MECKLENBURG COUNTY
Park and Recreation Department

MEMORANDUM

DATE: August 23, 2023

RE: Rezoning Petition #2023-069
PID# 19312102

**RZP-2023-069
 REZONING**

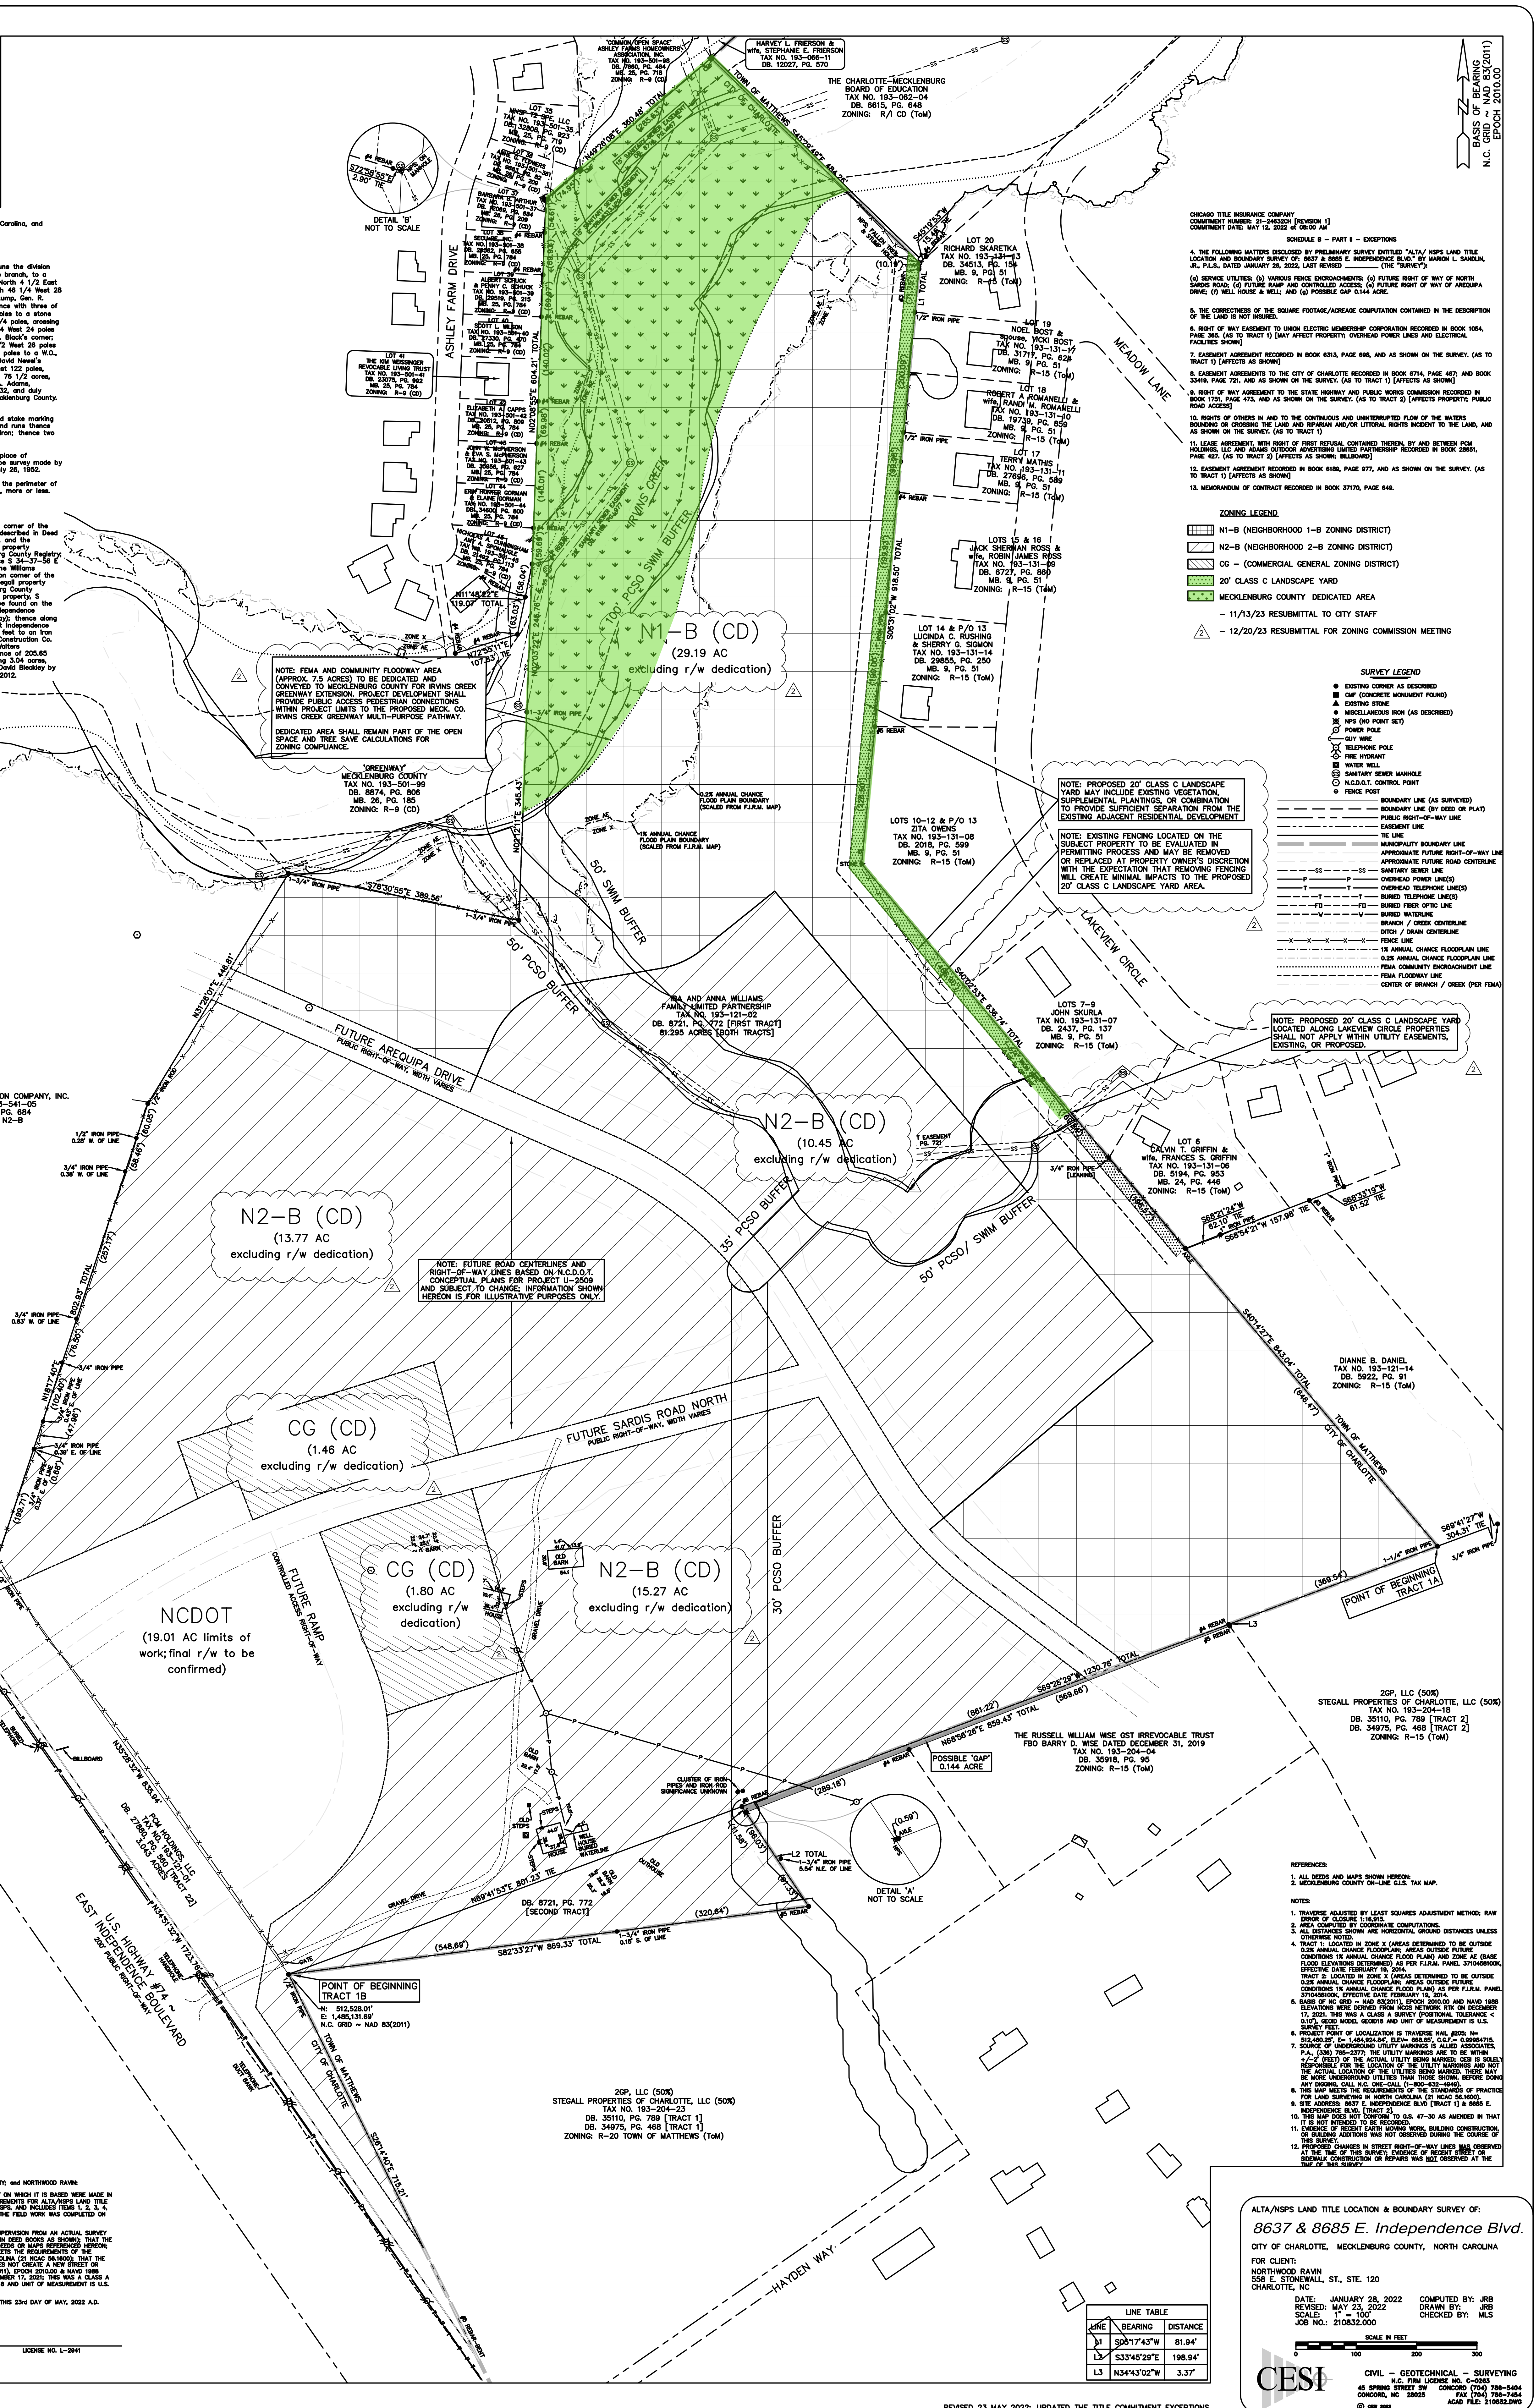
This parcel is on the MCPR Greenway Master Plan. MCPR requests the dedication and conveyance of the 100' SWIM buffer of Irvins Creek to Mecklenburg County as permanent greenway easement and a minimum 100' width permanent greenway access easement to Mecklenburg County in order to construct an accessible trail connection between Irvins Creek Greenway and the public street ROW. Greenway easements may overlap tree-save.

Additionally, MCPR requests minimum of 3.5 acres to be dedicated and conveyed to Mecklenburg County for a future local park. This requested park land shall be adjacent to a public right-of-way for access and is conducive for the development of the typical amenities found in a local park and cannot include tree save parcels or stormwater BMP's. Ideally, the proposed park land shall be adjacent to the requested greenway access easement.

Greenway easements and parkland dedication shall be conveyed by the first CO.
